**Re: Commercial/Retail Development at 86-96 & 100 Mount Street, North Sydney  
Heritage Impact**

Further to our Statement of Heritage Impact (Part 3A Environmental Assessment) for a Commercial Development 100 Mount Street, North Sydney (14 May 2009), we have reviewed your drawings which were prepared in response to comments arising from exhibition.

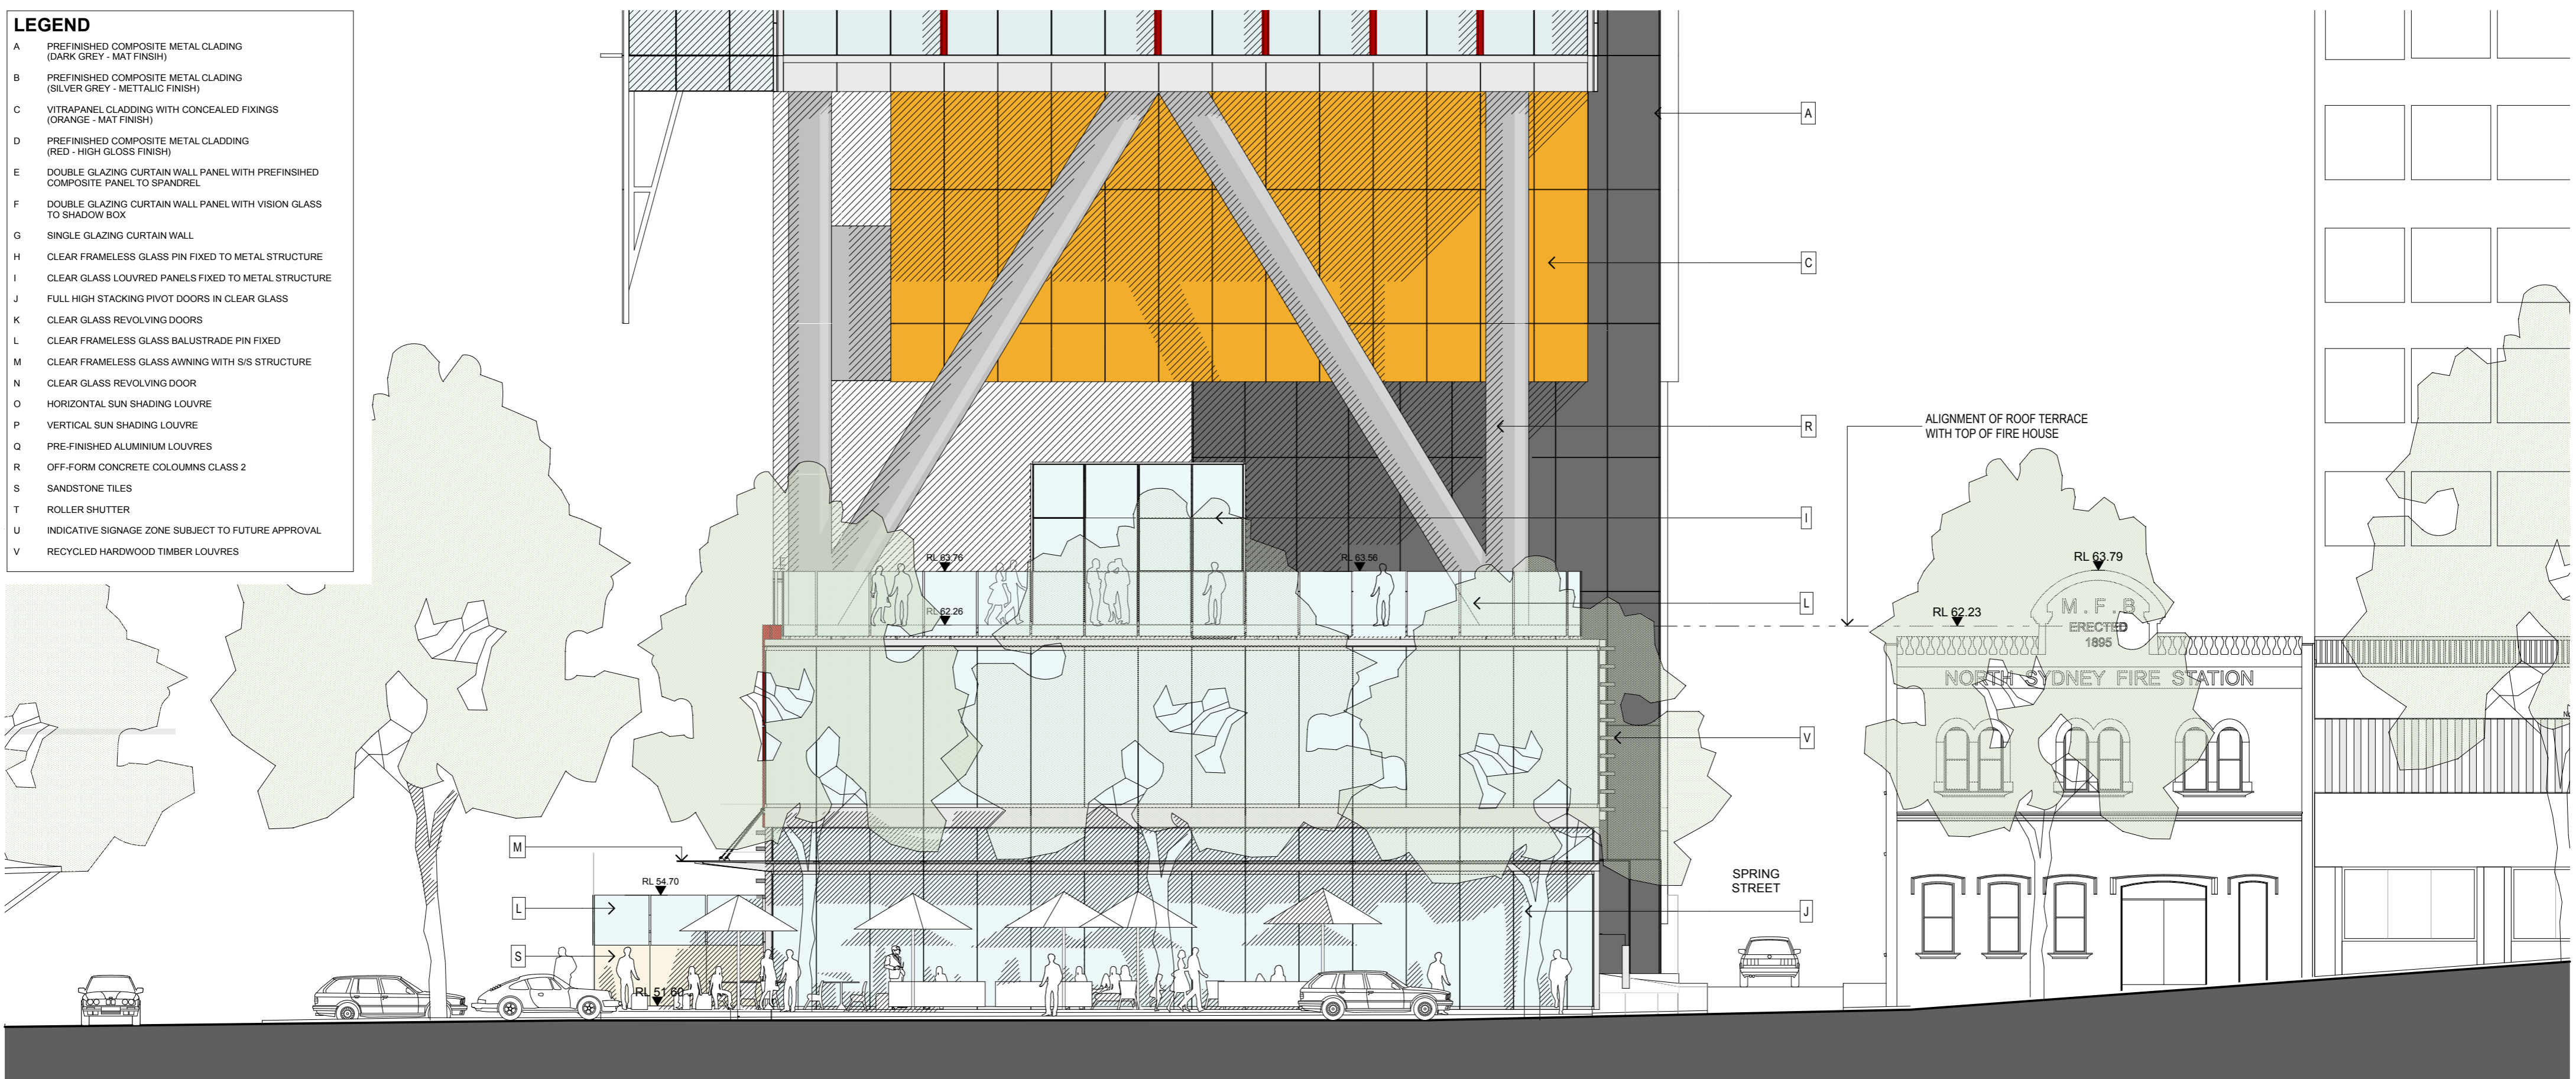
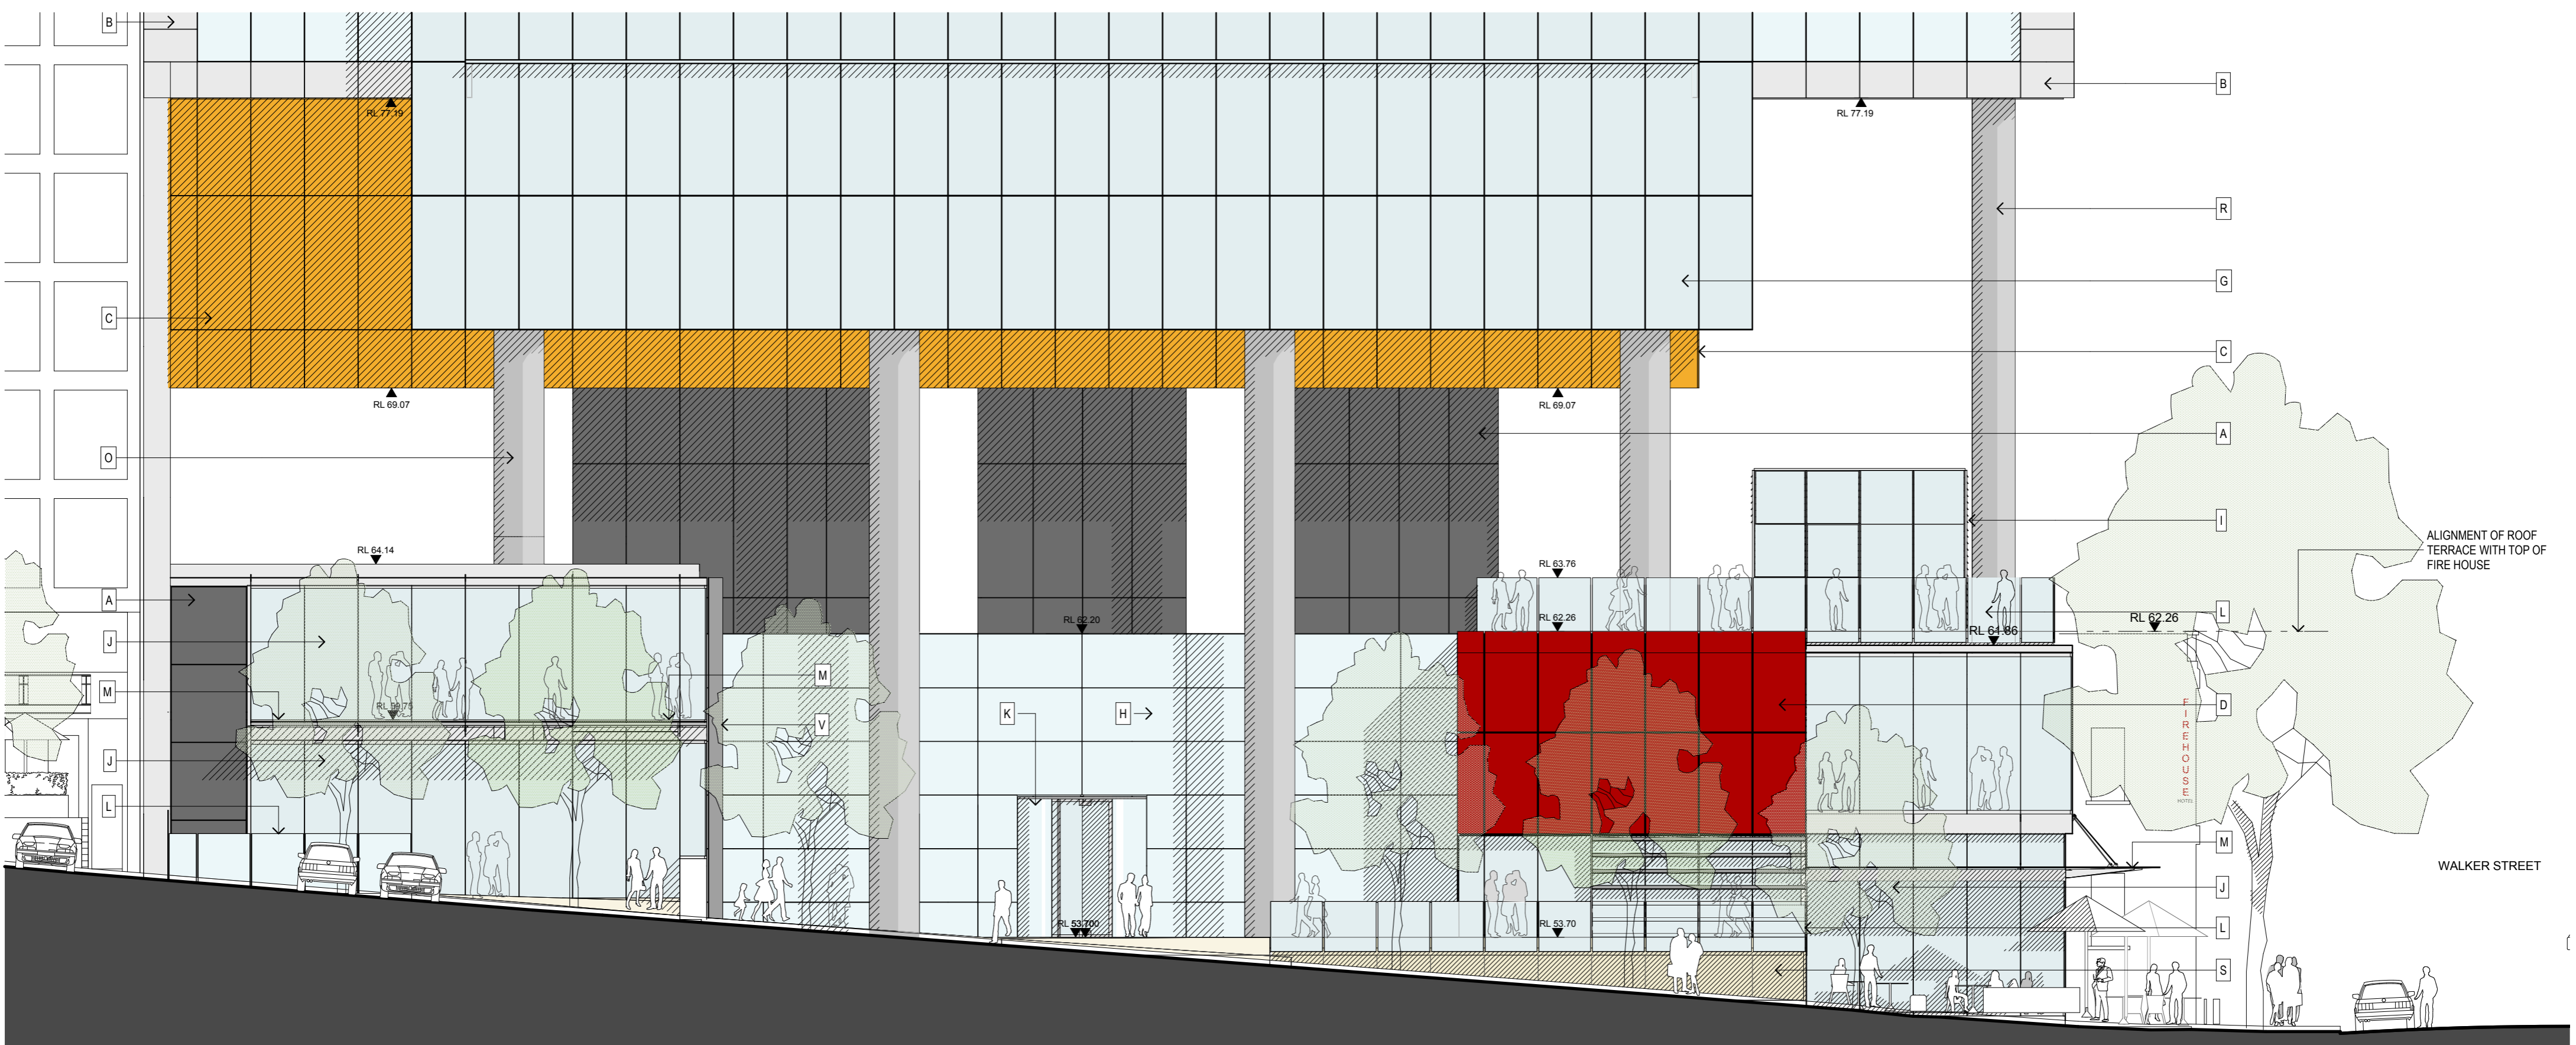
*The Department is concerned with the setback treatment of the proposed building along Walker Street between levels 8 and 12. Further design resolution of the exposed structural frame (concrete columns) is required. This may involve consideration of other design options for this area."*

*"The Panel also has considerable concern with the setback treatment of the building between levels 8 and 12. The recess above the two levels fronting Walker Street with the very assertive exposed structural frame is inappropriate in this context. This is not justified and is grossly out of scale with the building's setting."*

*"The podium of the proposed development is designed to sympathetically match that of the Firehouse Hotel providing an appropriate scale to respect the heritage item. The proposed off-form concrete columns, however, are not considered to be sympathetic to the Firehouse Hotel. The massive scale of the columns is overwhelming when compared to the Italianate detailing on the Firehouse Hotel. It is recommended that the columns are not expressed on the Walker Street façade such that the significance of the Firehouse Hotel is retained.....As noted above, the massing of the off-form concrete columns on the Walker St frontage are considered massively out of scale with the Firehouse Hotel, and the success of the glazed podium is lost by their aggressive assertiveness. The Walker St façade of the proposed tower is considered to be impolite and insensitive...The detailing of the glazed podium is simple and will allow the decorative features of the Firehouse to dominate the immediate streetscape when viewed from the western side of Walker St. The 1.4m diameter concrete columns that support the proposed tower, however, are considered to be vastly over scaled and will dominate the heritage item when viewed from the eastern footpath*

and across the intersection. It is recommended that the columns are not expressed on the Walker St façade. It is recommended that:

- Detail drawings at 1:50 or 1:20 scale that label the alignment and relationship of the decorative features of the Firehouse Hotel...be submitted.
- The angled off-form concrete columns are not to be expressed on the Walker St elevation so that the massing and scale of the development is appropriate to the height, massing and scale of the delicate and finely detailed Firehouse Hotel.
- A Schedule of Finishes to be submitted.”

Amendments to the exterior form of the design with potential heritage impacts include a revision to the treatment of the north and east elevations of the podium. The podium has been modulated on its eastern elevation and in plan to reflect the street rhythm set by the adjacent heritage item – the former Fire Station. This has been achieved by breaking the elevation into two equal parts and stepping one forward and one back and by further articulating the façade by the use of timber horizontal louvres/brise soleil. Minor changes have been proposed to the junctions and finishes of the expressed structural frame that crosses the void above.

The amended design further refines the relationship between the proposed building and the former Fire Station by repeating the vertical rhythm of the street and earlier subdivision pattern. More detailed design of the Walker Street elevation to ensure alignment of the elements of the existing and proposed would ensure mitigation of impacts in the execution of the work. The structural frame of the void and the scale of the void itself are expressed above the height of the former Fire Station and the key elements that would be perceived between it and the proposed building are limited to the lower levels of the podium interface. The expressed structural frame above would be outside the immediate perception of the relationship between the new building and the heritage item. The design of the structural frame or other support for the tower above the void are issues of an architectural and urban design nature rather than heritage issues per se. Consequently, the void and frame should be considered in light of the wider existing and proposed context and in light of the building as a whole.

We confirm that the design, as amended, has a minor and acceptable impact upon the former North Sydney Fire Station and other heritage items.
